TfNSW Reference: SYD20/00117/04

DPIE Reference: SSD 10425

**STAGE 2 MIXED USE DEVELOPMENT INCLUDING 987 RESIDENTIAL UNITS,
3000SQM COMMERCIAL, AND 6000SQM RETAIL - TALLAWONG STATION
PRECINCT SOUTH, ROUSE HILL**

Soil and Water Management Plan

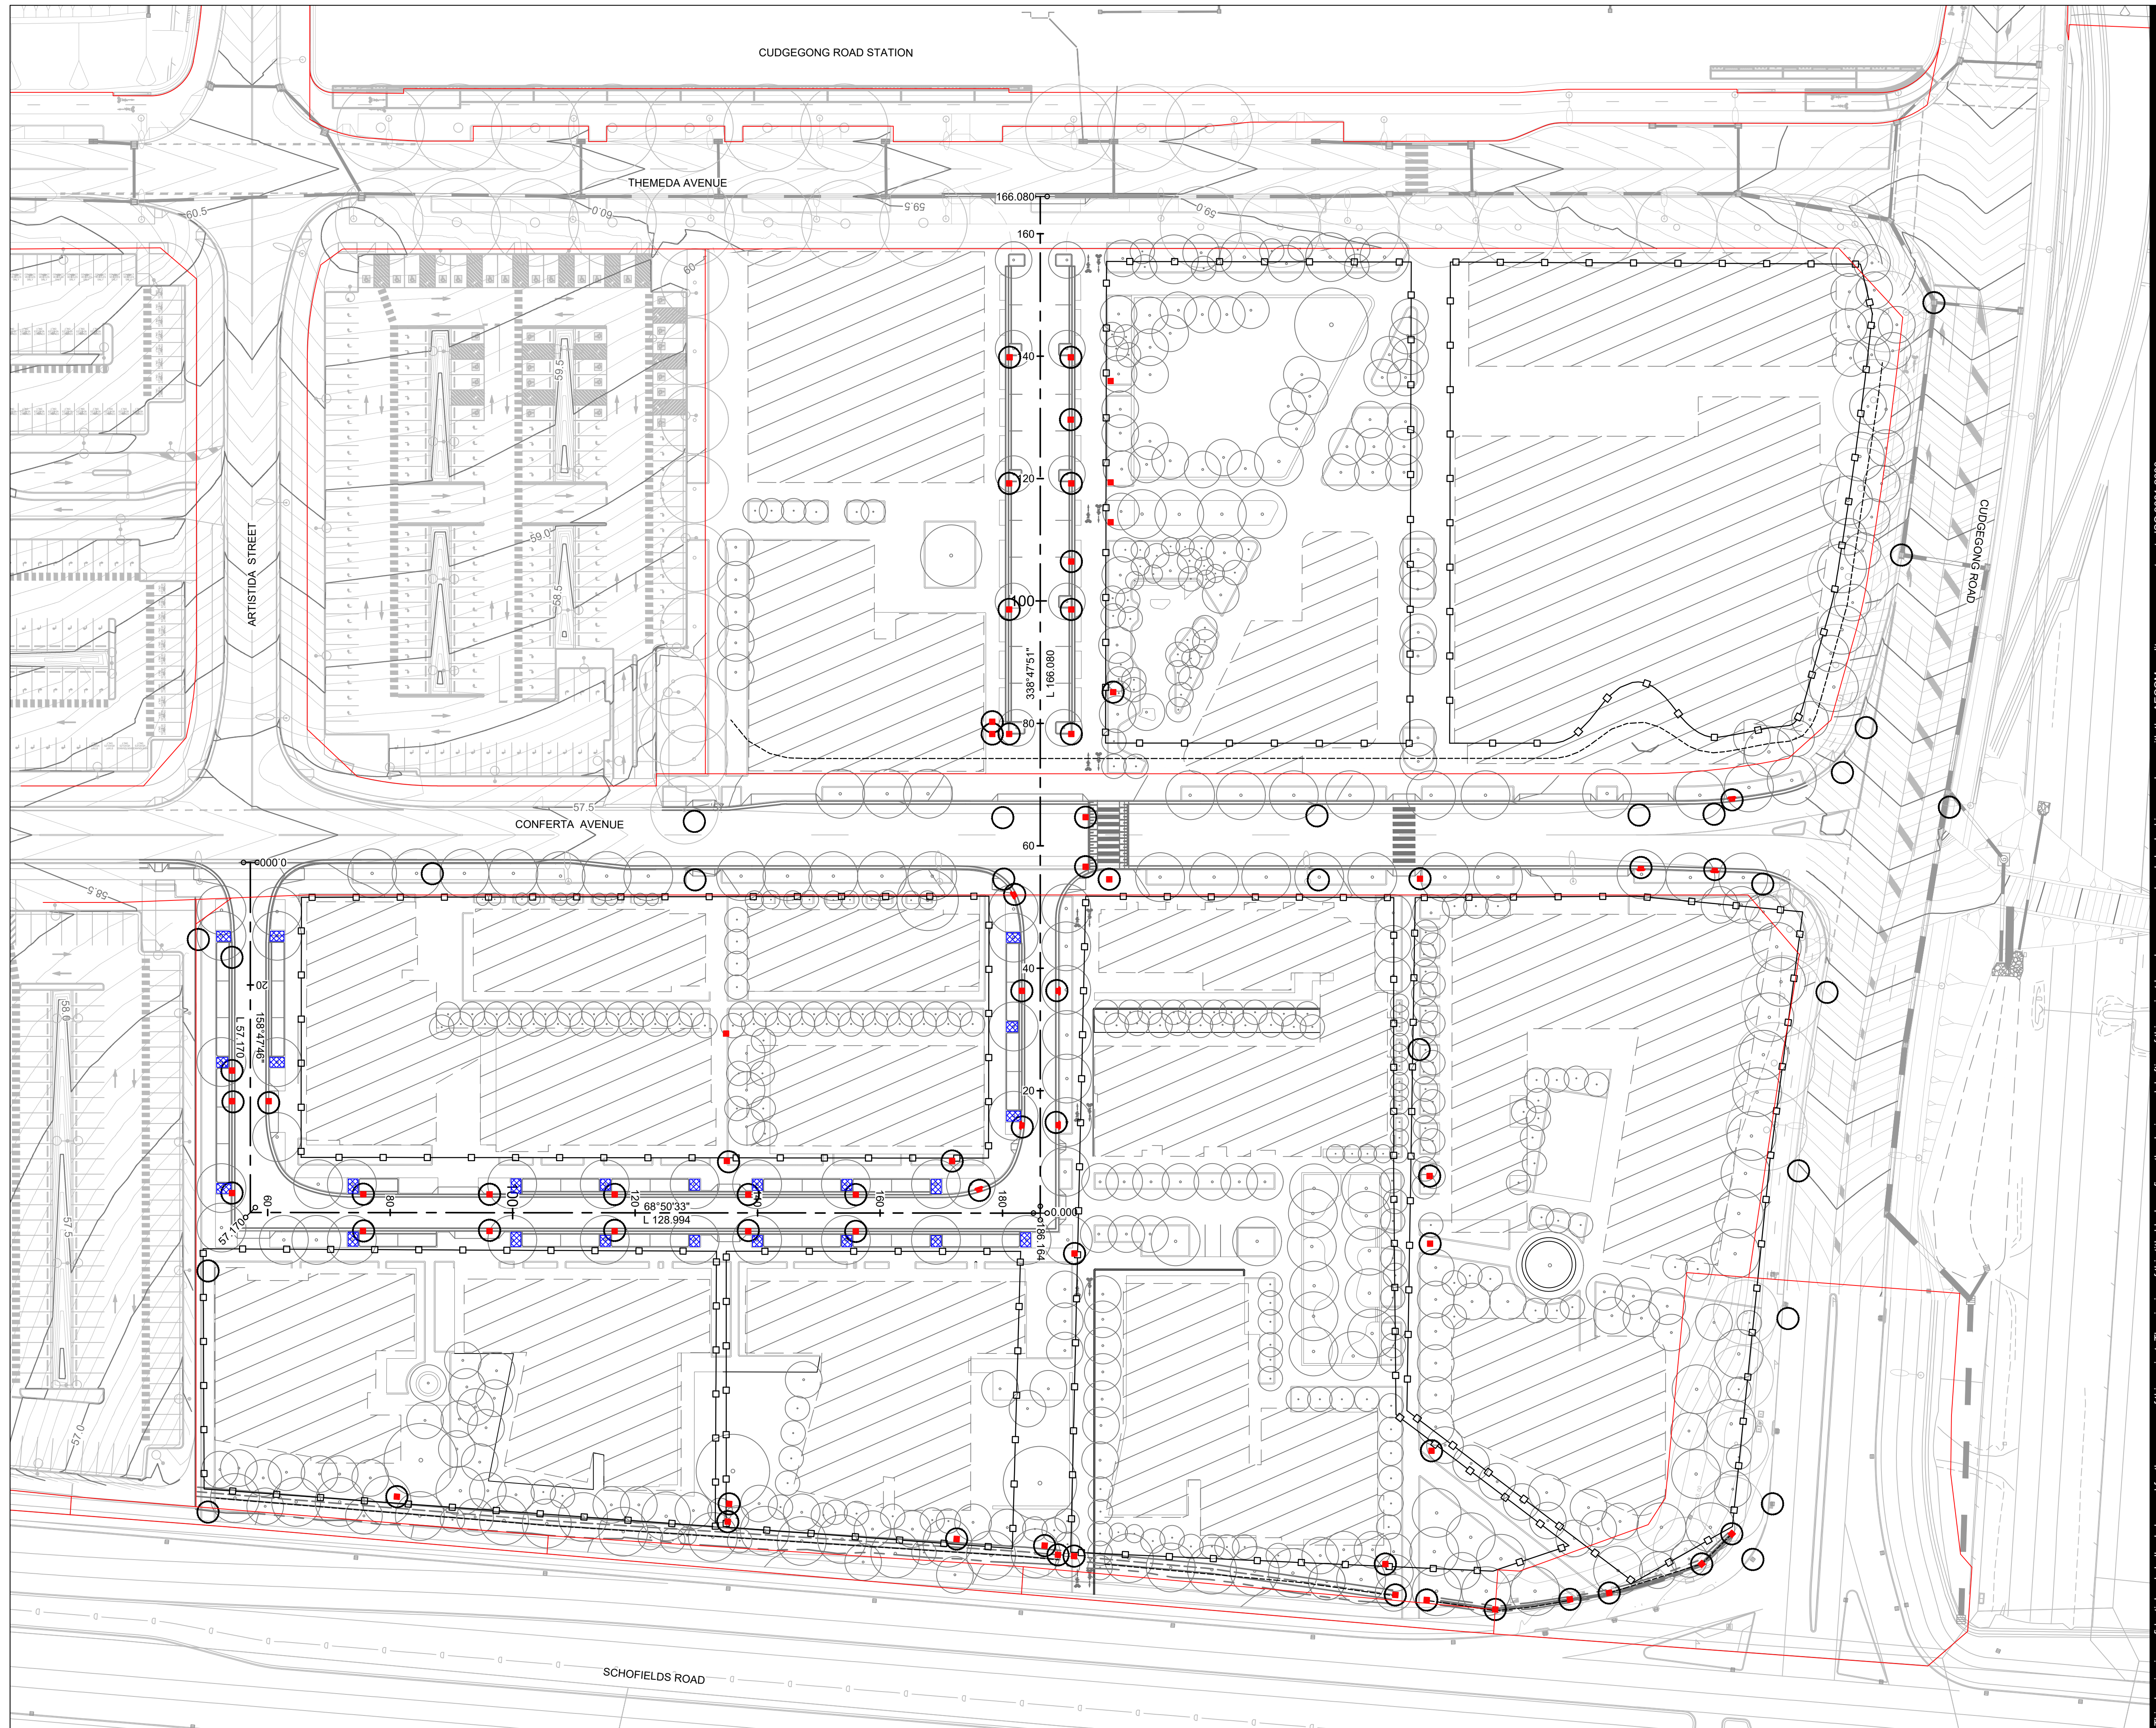
It is noted that the submitted plans show pedestrian paths, erosion and sediment control measures such as fencing, and site office and amenities on TfNSW owned land. The plans are to be amended accordingly to ensure the development and associated infrastructure is located entirely within the development site.
